MODIFICATION REQUEST:
Mixed Use Development
44-46 Walker Street, Rhodes
MP 10_0105 MOD 1

Director-General's
Environmental Assessment Report
Section 75W of the
Environmental Planning and Assessment Act 1979

September 2012

Date	Scale	Sheet Size
18.04.2012	1 : 200	@ B1
Reg No.	Drawn	Chk.
	MM/NH	JP
Job No.	Drawing No.	Revision
4410	A-0505	A-2

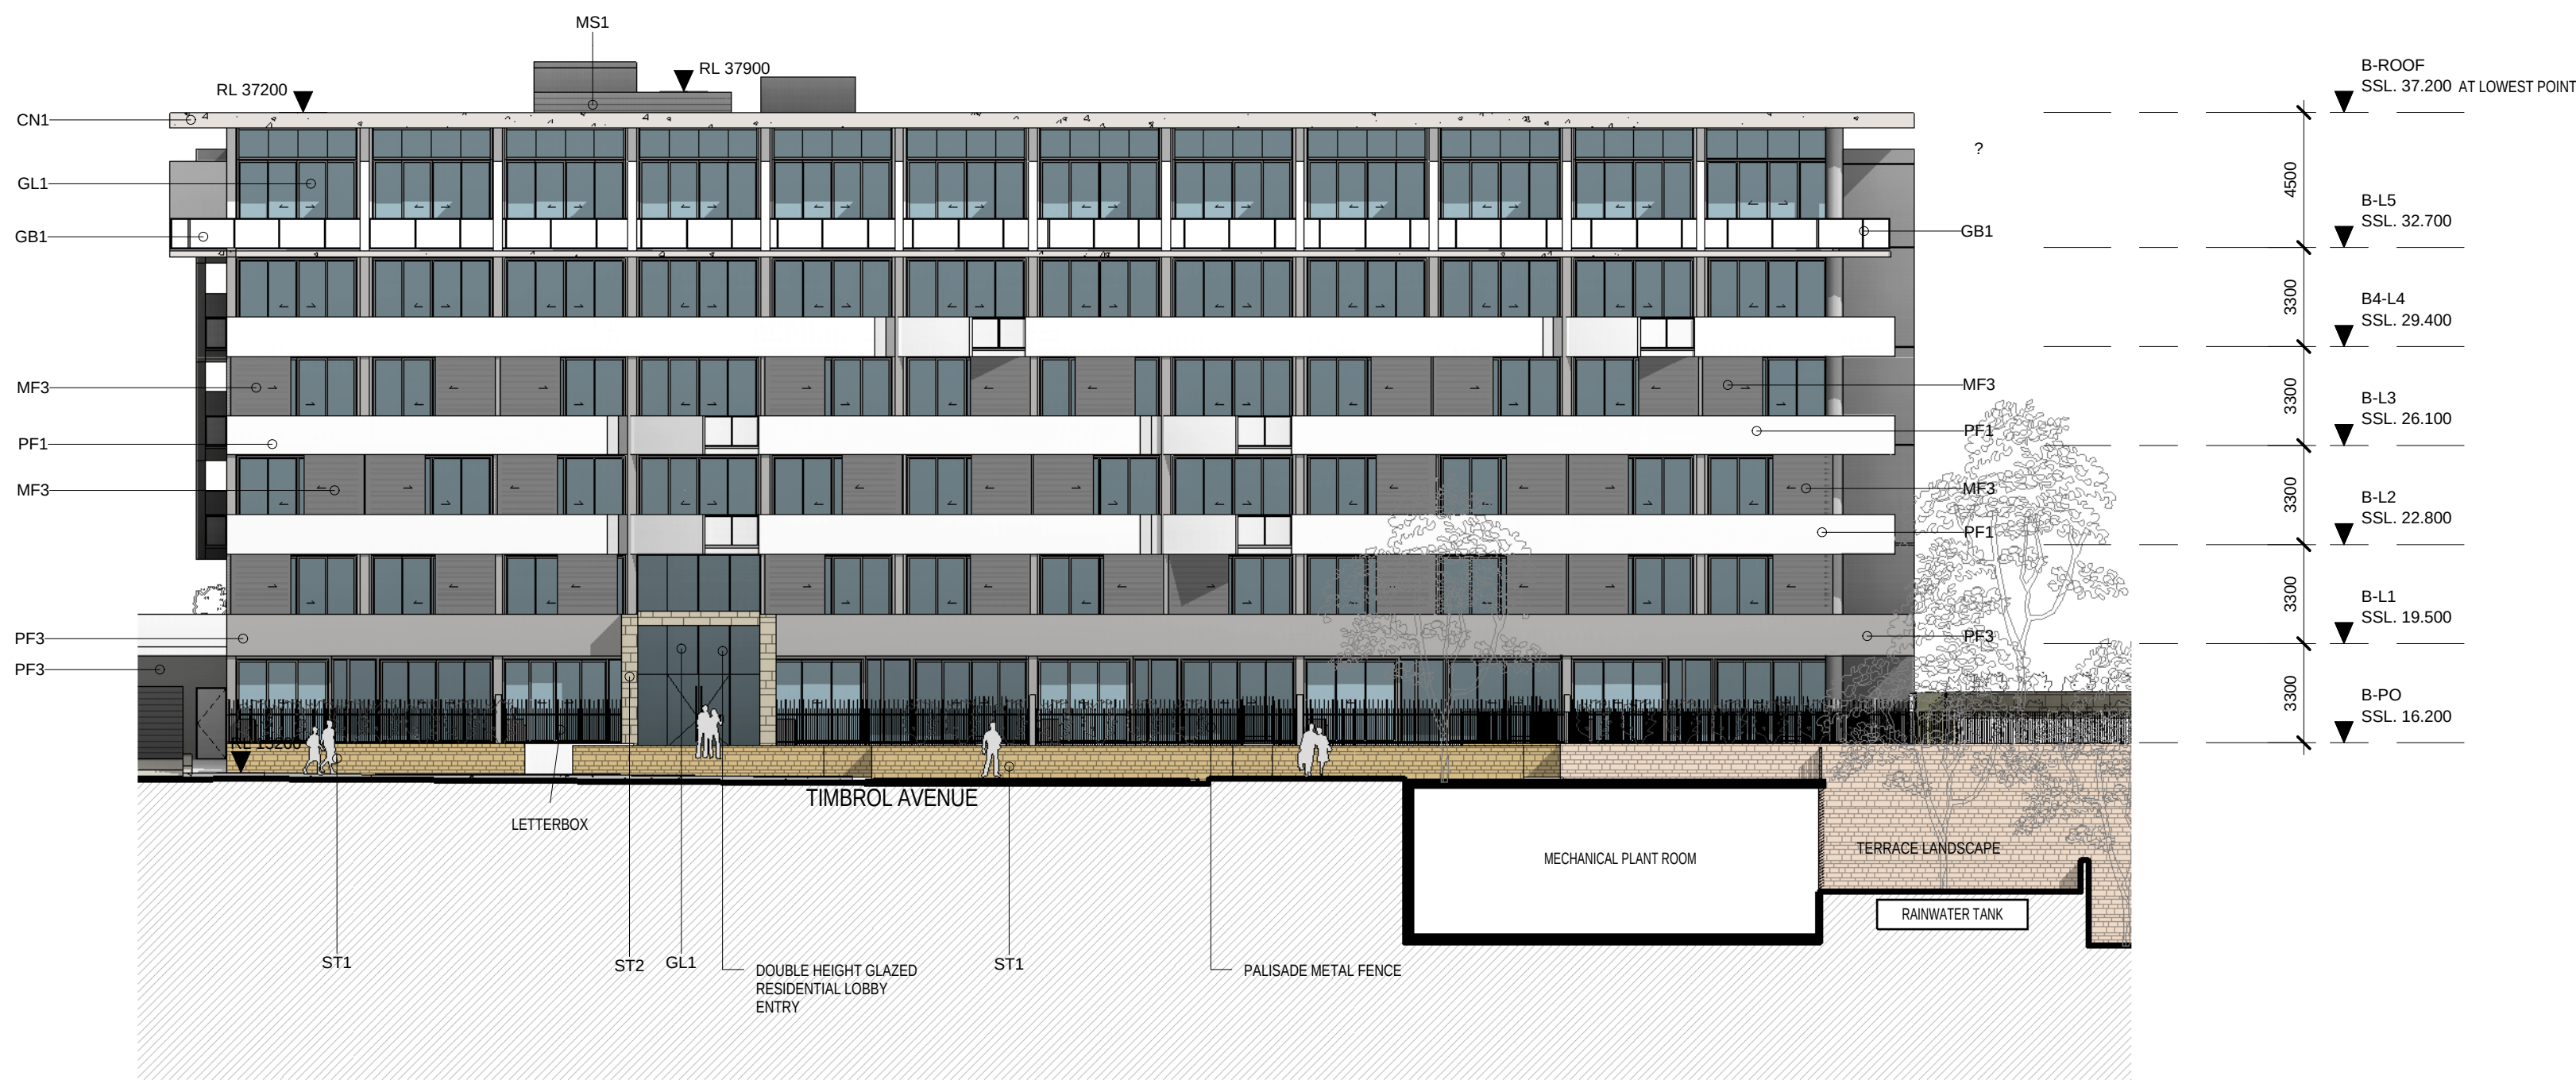
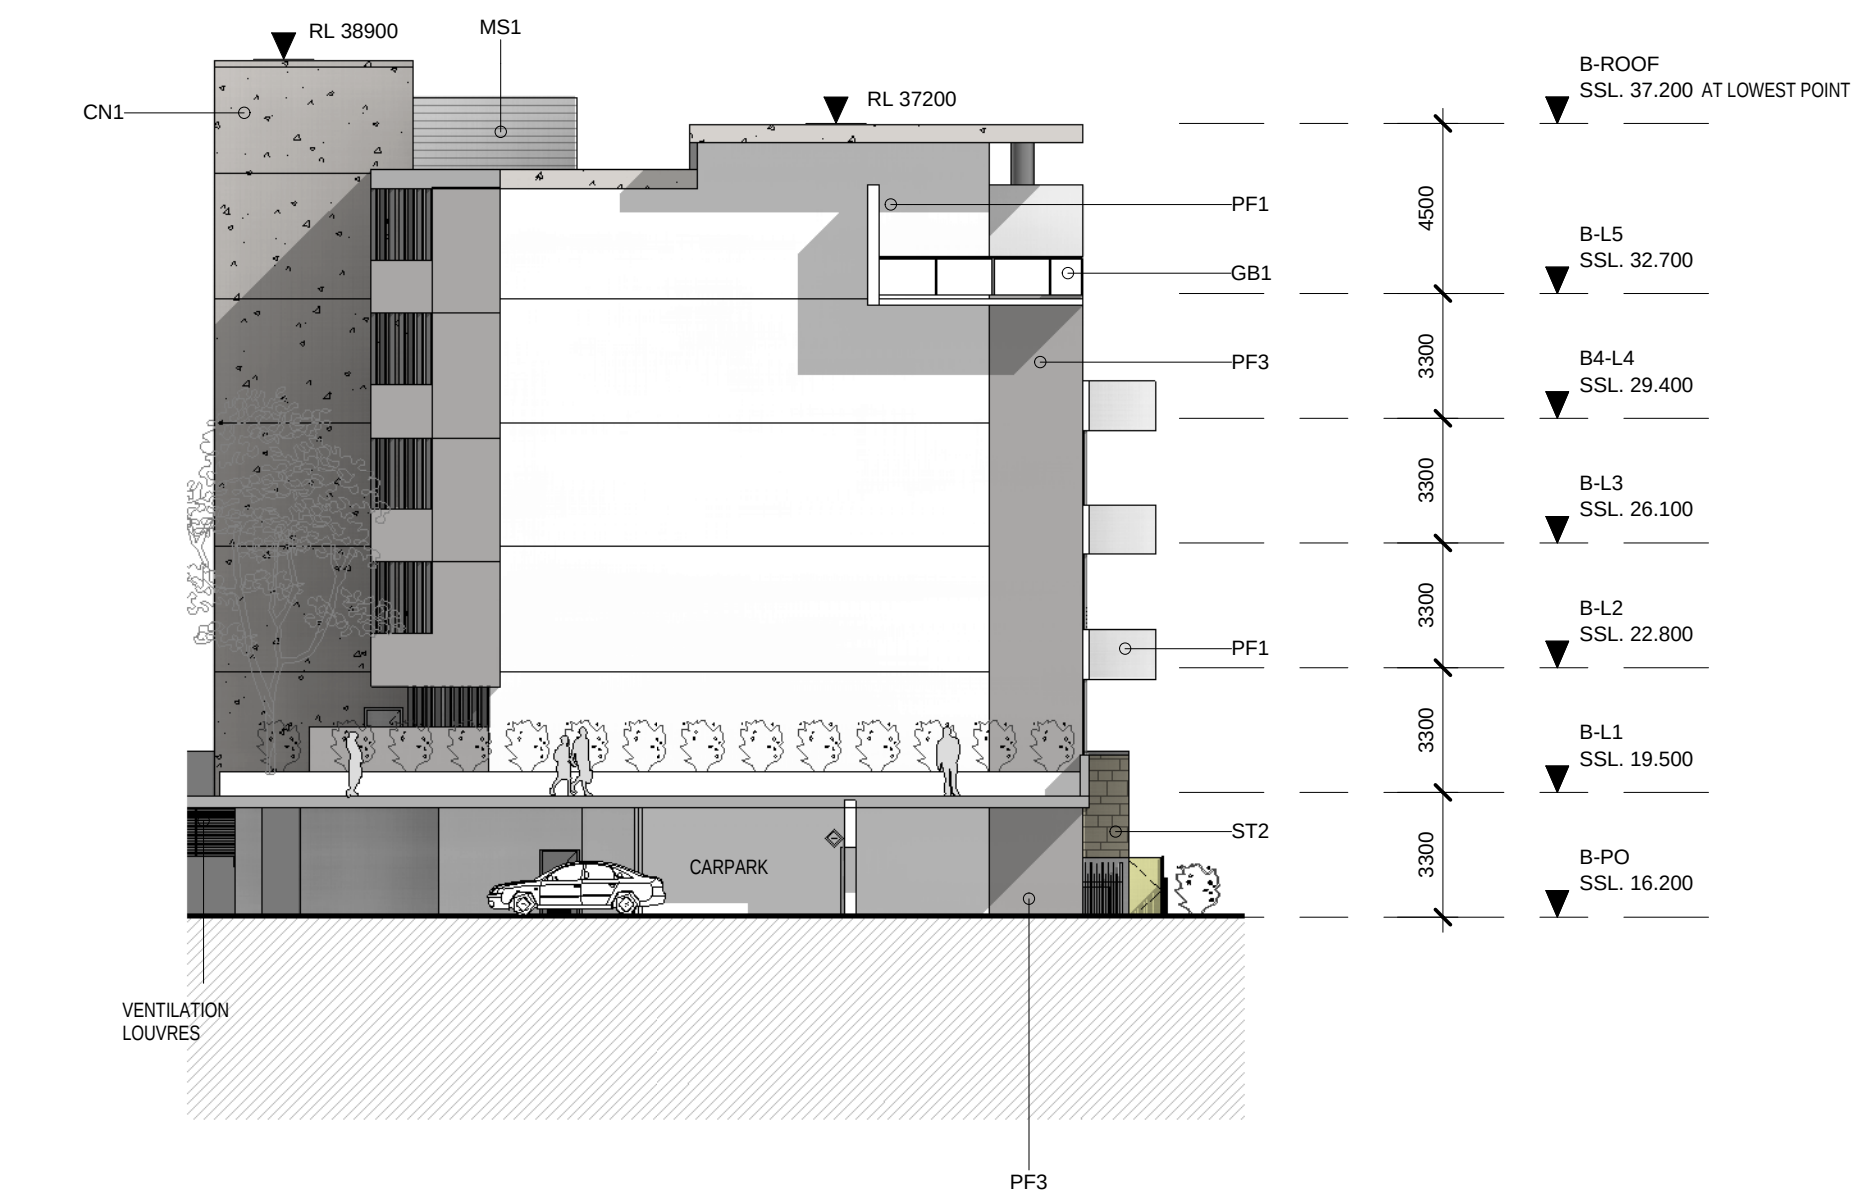
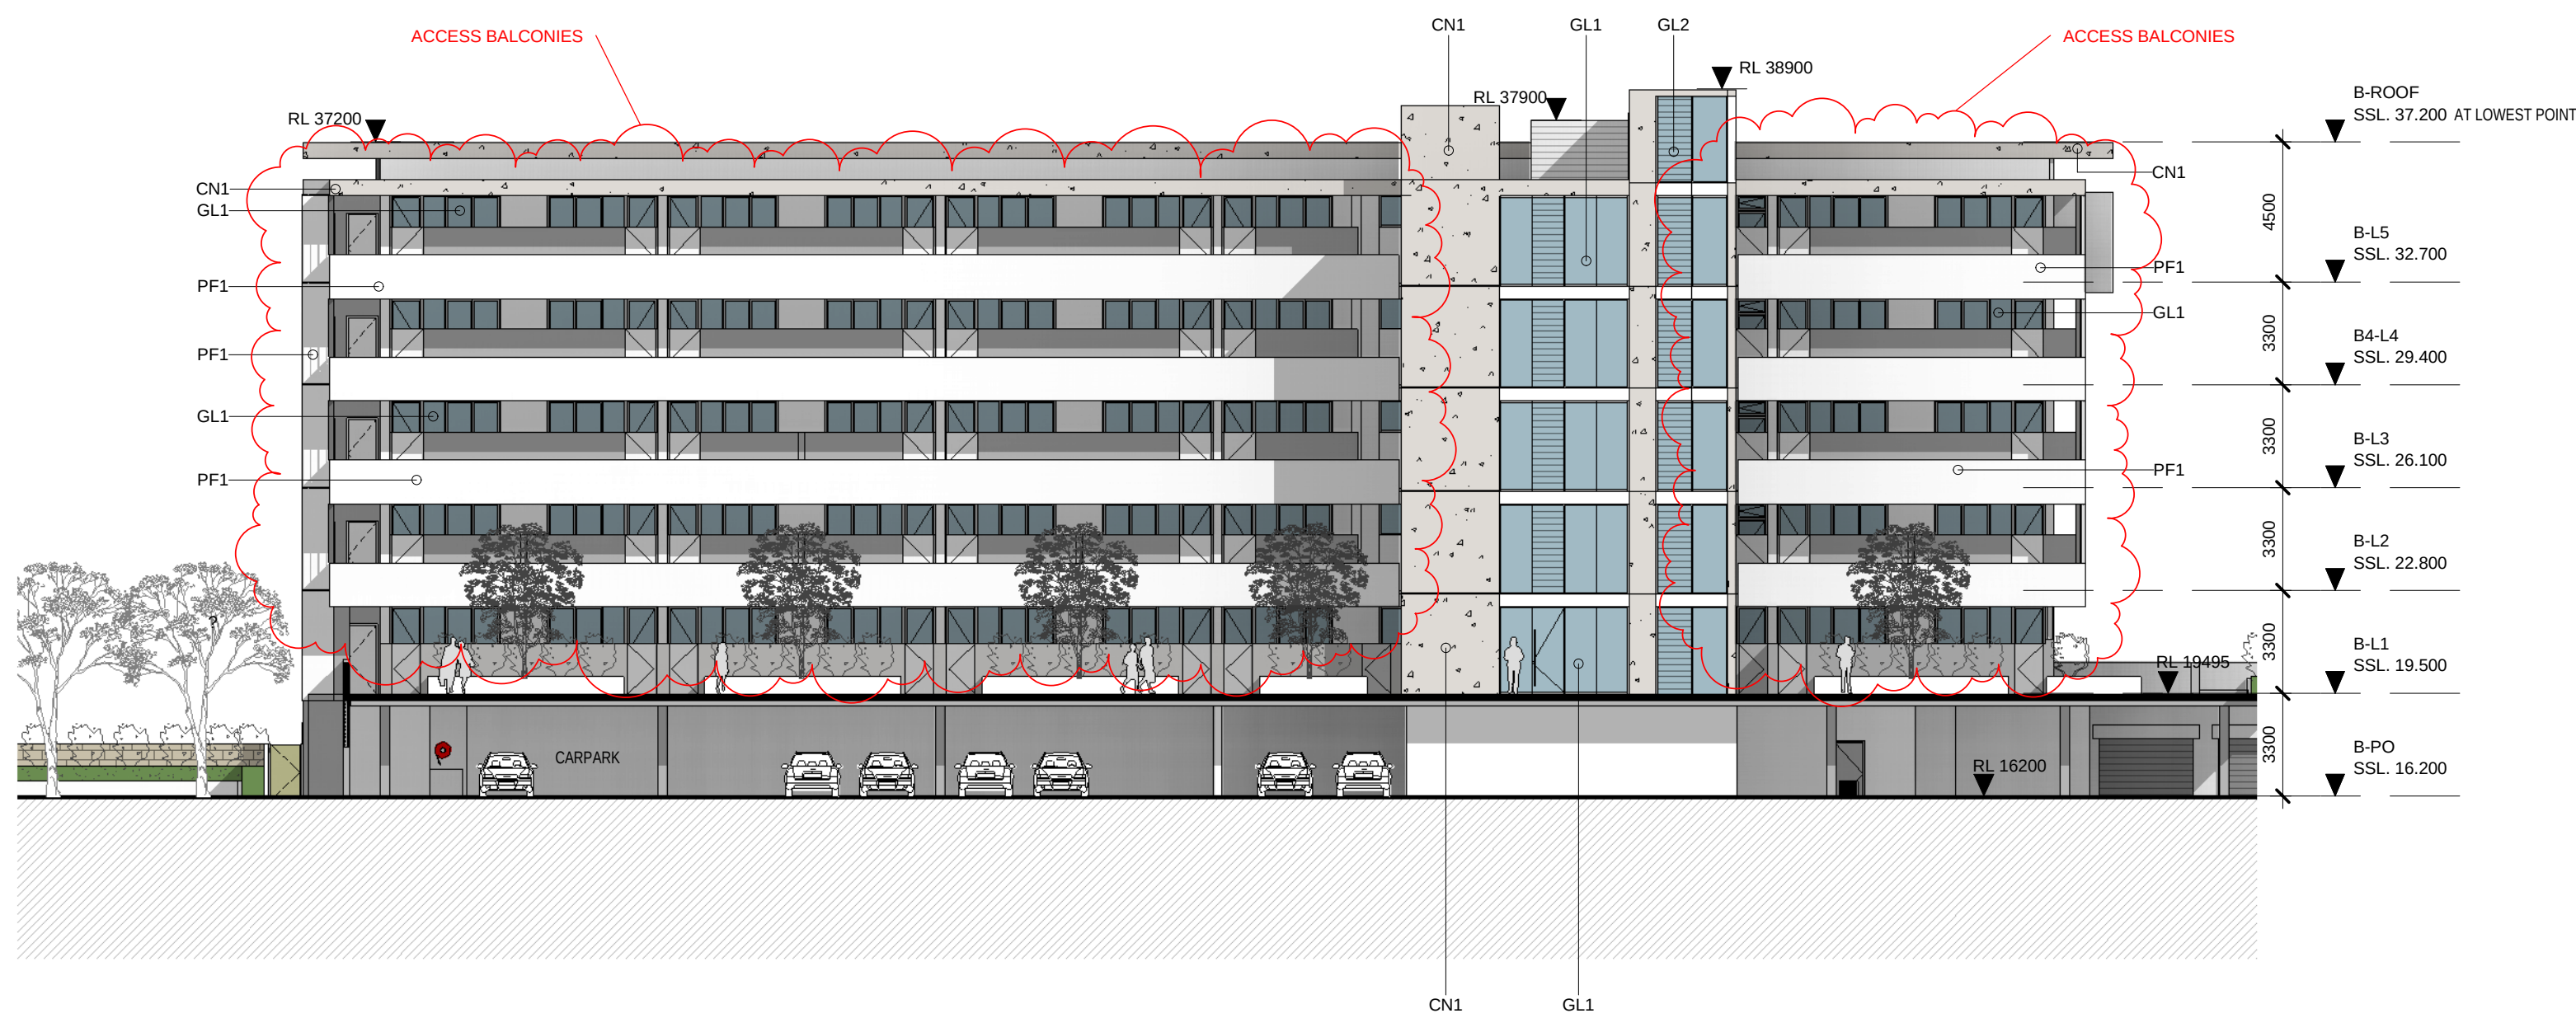
- Levels 2 to 5 – revisions to the southern access balcony.
- Minor changes to the stair core at two locations.
- Modification of glazing elements at apartment 5.01 (level 5 only).

The revisions to the southern access balcony to apartments at levels 2 to 5 are proposed in order to provide additional privacy for building occupants and improved amenity. The department does not raise any concerns with the proposed minor amendments to Building B.
